Planning Application Reference No.: 03/2023/0068

Address of Development: Clitheroe Castle PINNACLE GARDEN

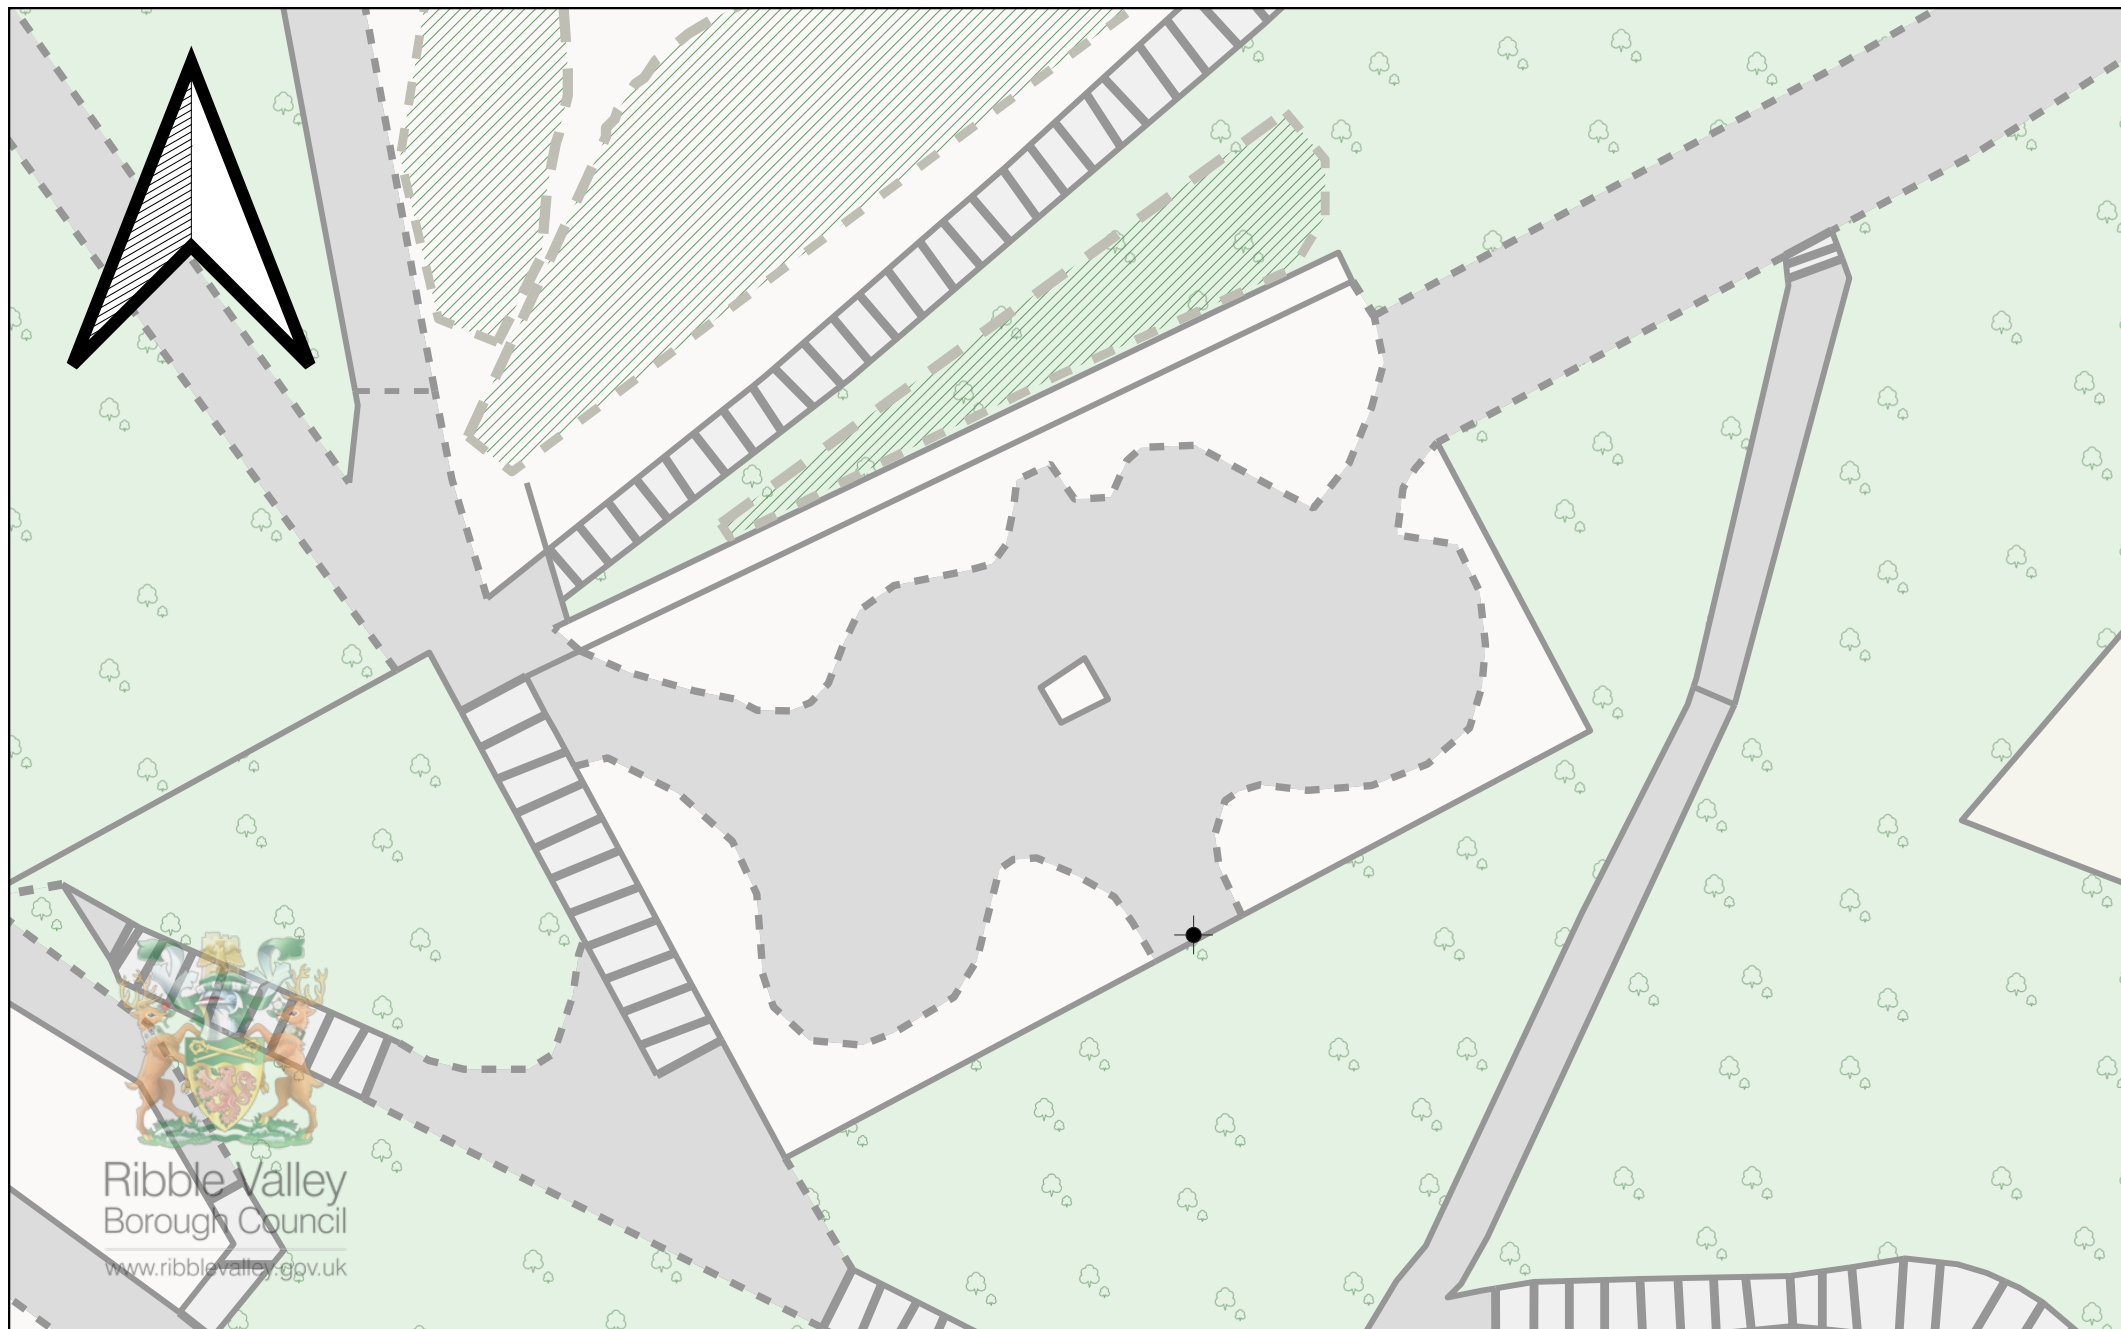
The actual location of this new plaque requires further consideration and a precise location indicated as part of the application. This to avoid distraction from these other features - so all can be best appreciated. This should not be left to a decision 'on the day'. If this information is not requested and/or not provided then the application should be deferred until it is, or refused if it is not.

Rose-Garden Location Plan

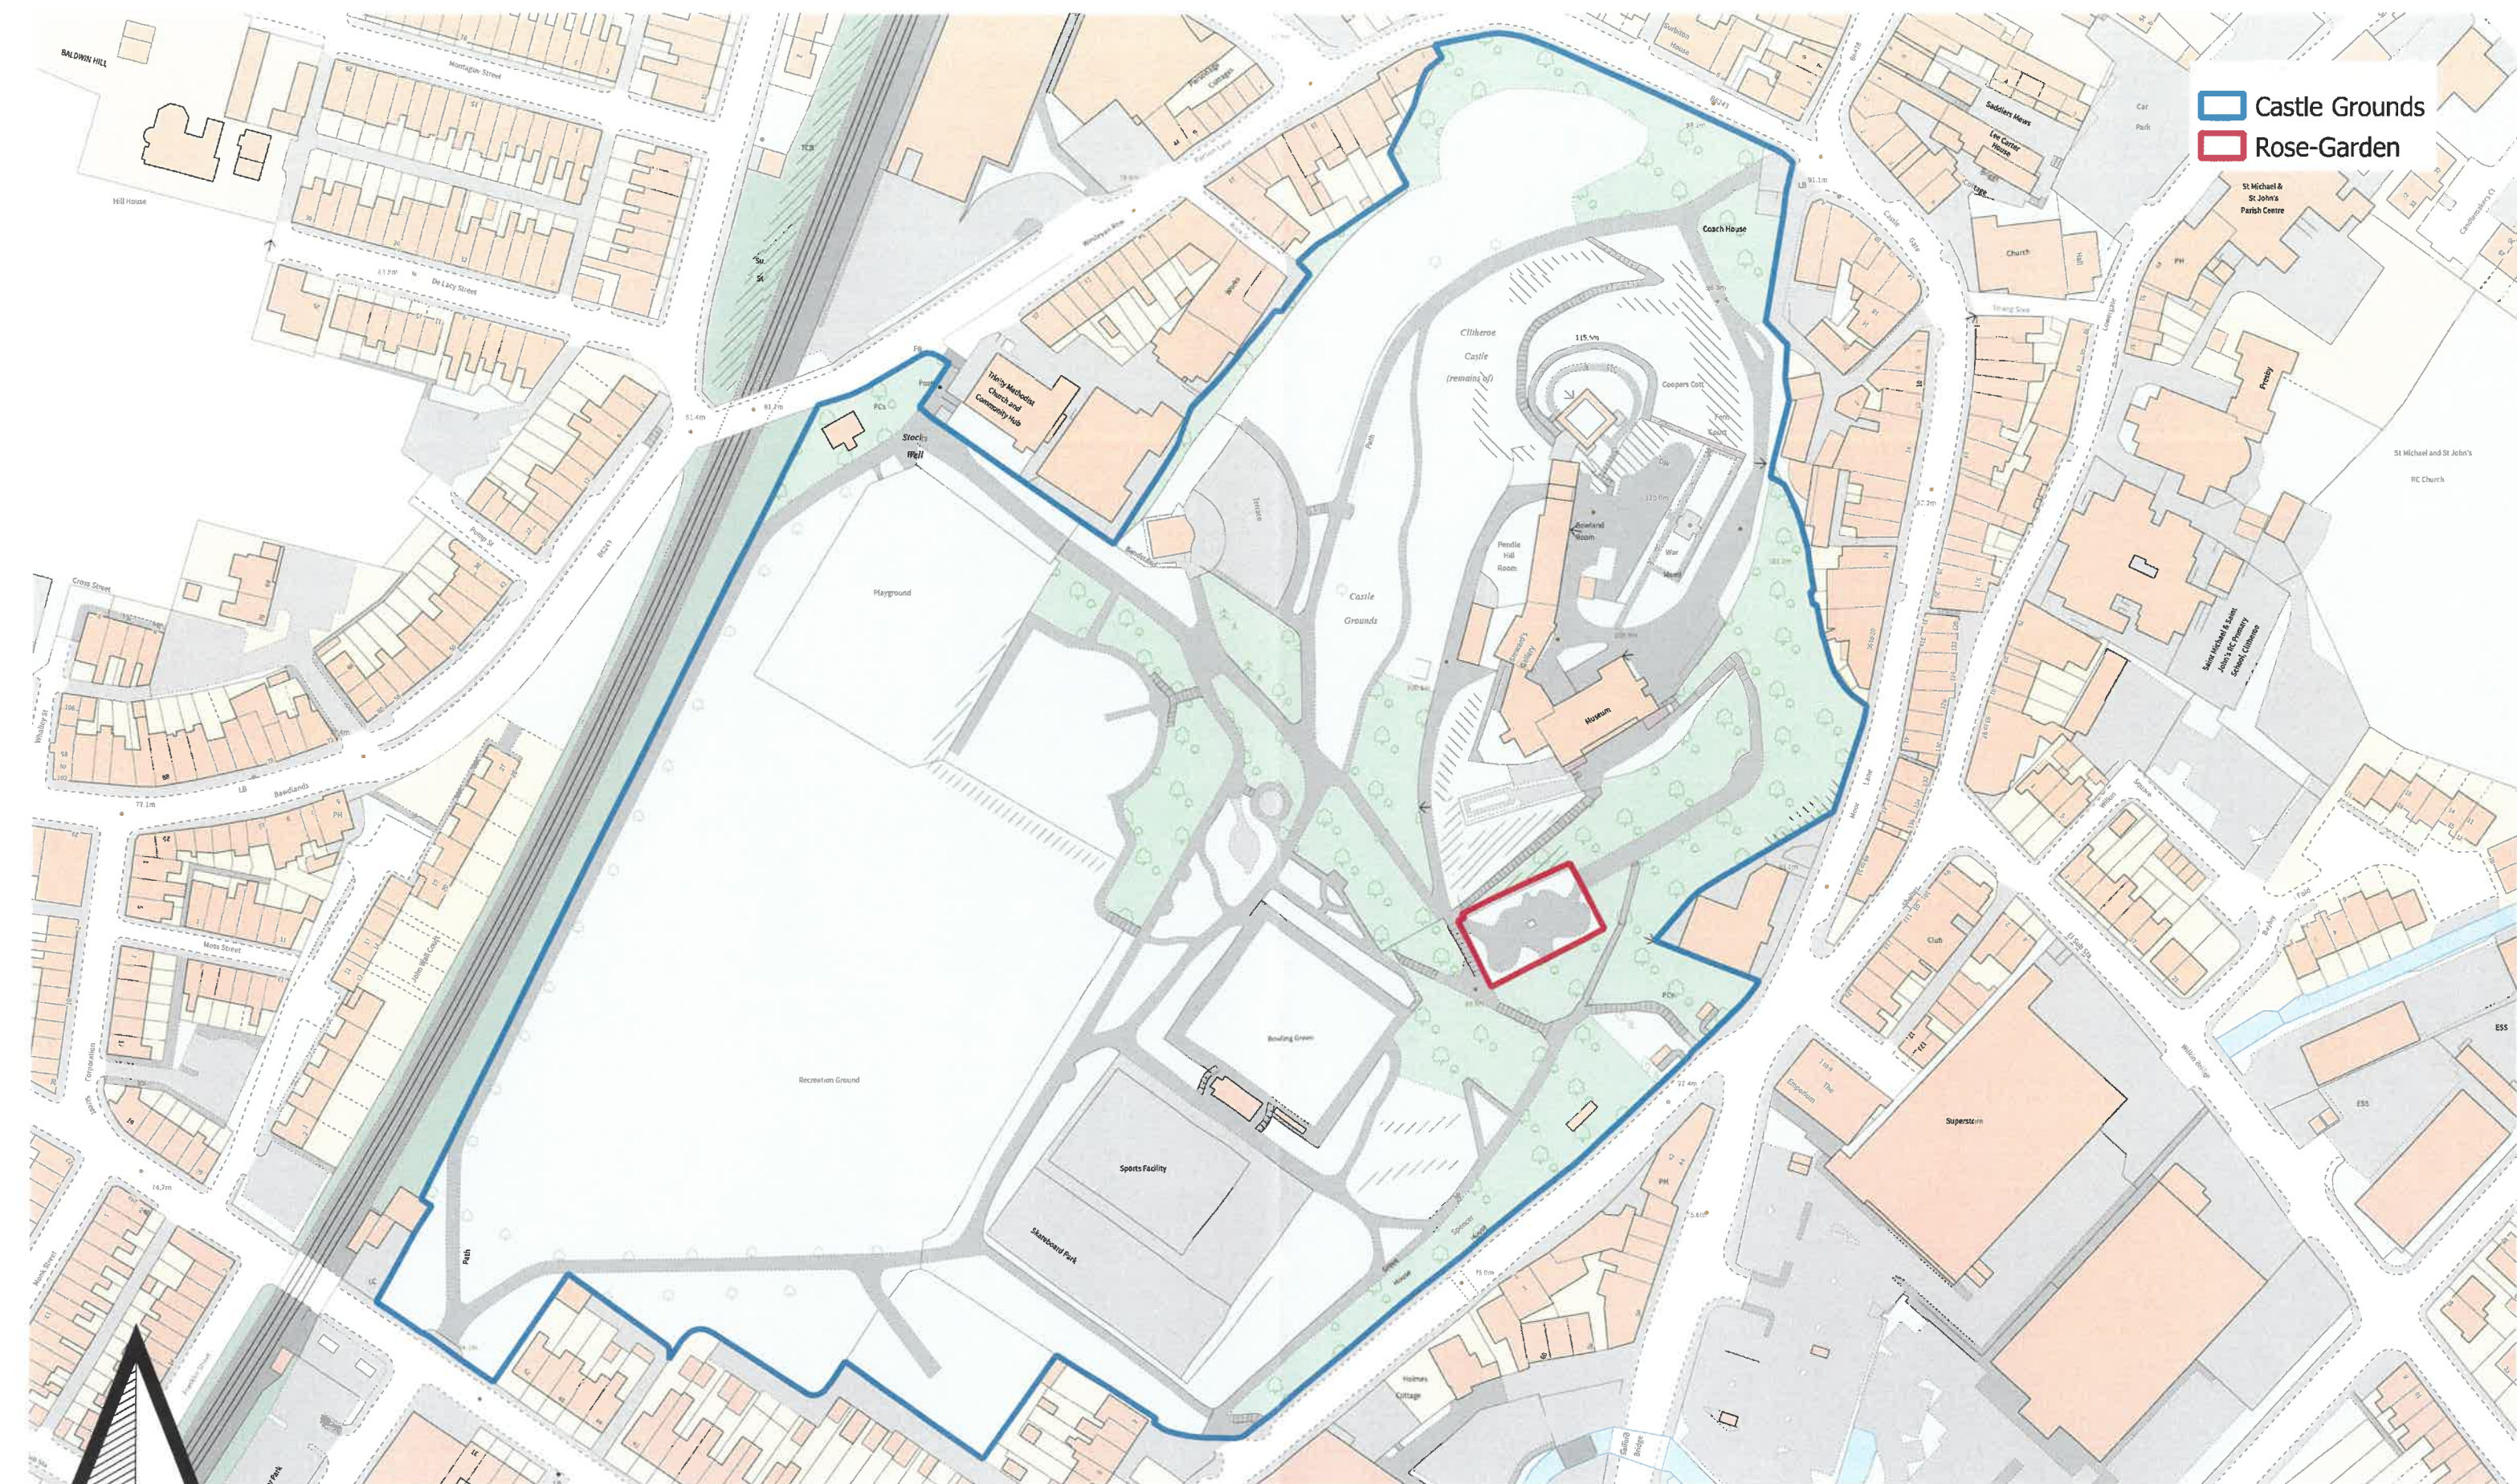
My only concern, and objection, to the proposals is the absence of precise information on its intended location. The approximate Location Plan accompanying the application appears to put it in very close proximity to the Pinnacle Project Interpretation Plaque and plinth and also the 2005 Community Garden's Leaping Salmon Stone sculpture.
